City of Albuquerque Stormwater Construction Site Inspection Report

ESC File No.	H13E109A	Project Name:	Sandia Lab FCU		
NPDES Id. No.	NMR1004MR & '4U0	Location:	1100 Rio Grande Blvd NW		
7/21/2023	Owner	Contractor			
Operator	Garcia Real Estate Investments, LLC	Insight Construction			
Contact name & title	Ed Garcia	Dave Brown			
e-mail	ee Garcia@garciacars.com	Dave@insightnm.com			
Contact Phone #	505-259-0339	505-506-8412			
COA Inspector	Chancellor English	Start/End Time:	9am		
Construction Phase:	Building and infrastructure				
Type of Inspection:	Regular	Storm Event	Past Storm Event >0.25"	311/Complaint	Follow Up
Weather at time of inspection?	clear		Temperature:	~	90
Estimated date of last storm 0.25" or greater	5/22/2023

SWPPP INFORMATION SIGN (S)
N.T.S.

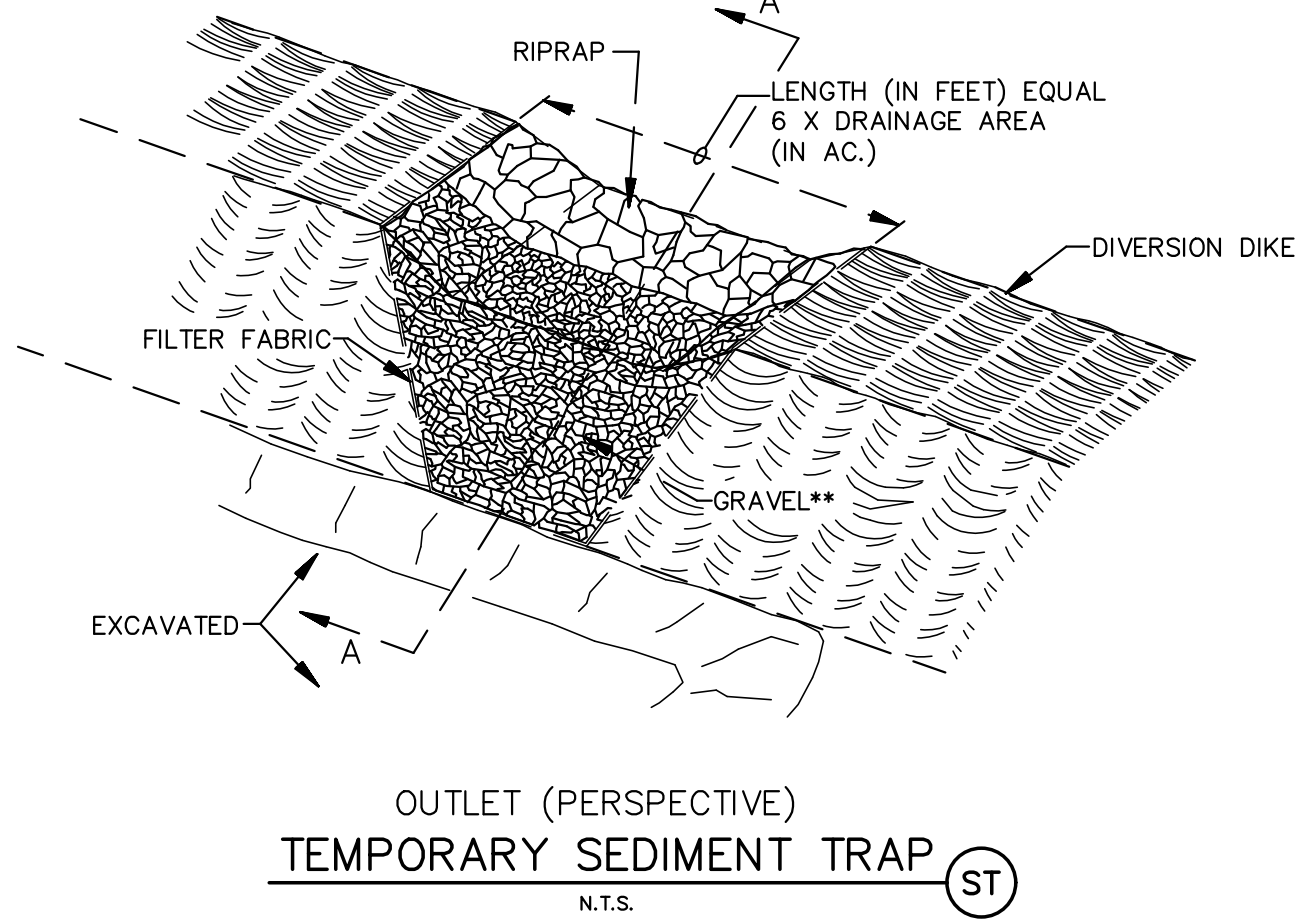
Item Number	Deficiency/ Corrective Action				
1	Posting - Incomplete. Required mitigation: The NPDES ID # and contact names and phone numbers of both the owner and contractor are missing and must be included on the sign per CGP Section 1.5.				
2	SWPPP - certification page missing signatures of the owner and the contractor. Required mitigation: Your signatory must sign and date your SWPPP in accordance with Appendix G, Part G.11 as per CGP Section 7.2.10.				
3	Washout - Concrete debris and residue from washout is on the ground. Required mitigation: Remove and dispose contaminated soils and hardened concrete with other waste in per CGP 2.3.3.e. Direct all future wash water from concrete, paint, and stucco into a leak-proof container and do not allow liquid wastes to be disposed of through infiltration or to otherwise be disposed of on the ground per CGP 2.3.4
